**From:** Contact Centre (CRM) <contact@ribblevalley.gov.uk>  
**Sent:** 05 July 2024 12:05  
**To:** Planning  
**Subject:** Planning Application Comments - 3/2024/0451 FS-Case-628459738

**Planning Application Reference No.:** 3/2024/0451

**Address of Development:** Dog and Partridge  
Hesketh Lane  
Chipping  
PR3 2TH

Site: **EXISTING SITE DRAINAGE LAYOUT**

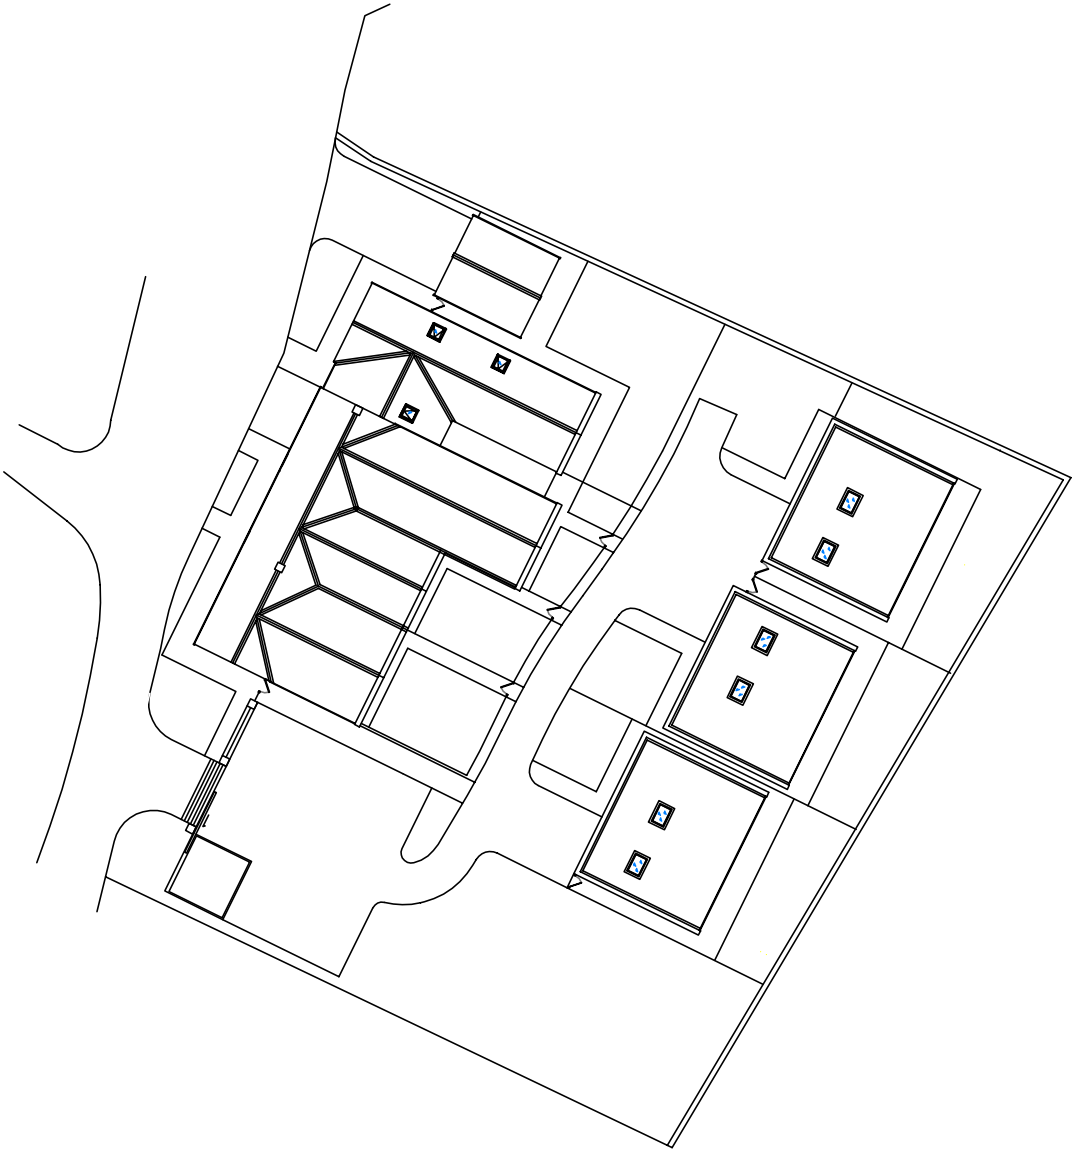
**Comments:** I am writing to you in relation to the proposal for discharge of condition 5 of the planning decision relating to planning permission 3/2023/0156 on 20th October 2023. As part of the planning consultation at this time 3rd party responses were made that included mention of an existing water drainage pipe that exits through the [REDACTED] and the Dog and Partridge and then drains across the tarmac surface and draining in to a surface water drain. This is a longstanding drainage and is thought to run across the [REDACTED] and under Hesketh Lane providing surface water drainage from Hesketh Lane highway drain. Of note, during times of rainfall there is significant water flow and discharge from this pipe.

A significant amount of work has now taken place on the Dog and Partridge site. As part of this a cap has been placed over the drain described above. When this cap is in place and rain fall occurs water backs up in this pipe. When this happens water backs up and causes flooding on the [REDACTED] and further up along Hesketh Lane. This is causing damage to the [REDACTED] and the surface of Hesketh Lane. The course the water takes and the erosion it is causing can be clearly seen along Hesketh Lane, especially then there is rain fall.

I would be grateful if you could ensure that the management of this highway surface water drain that crosses [REDACTED] and on to the Dog and Partridge site is included in the surface water drainage plans for the site.
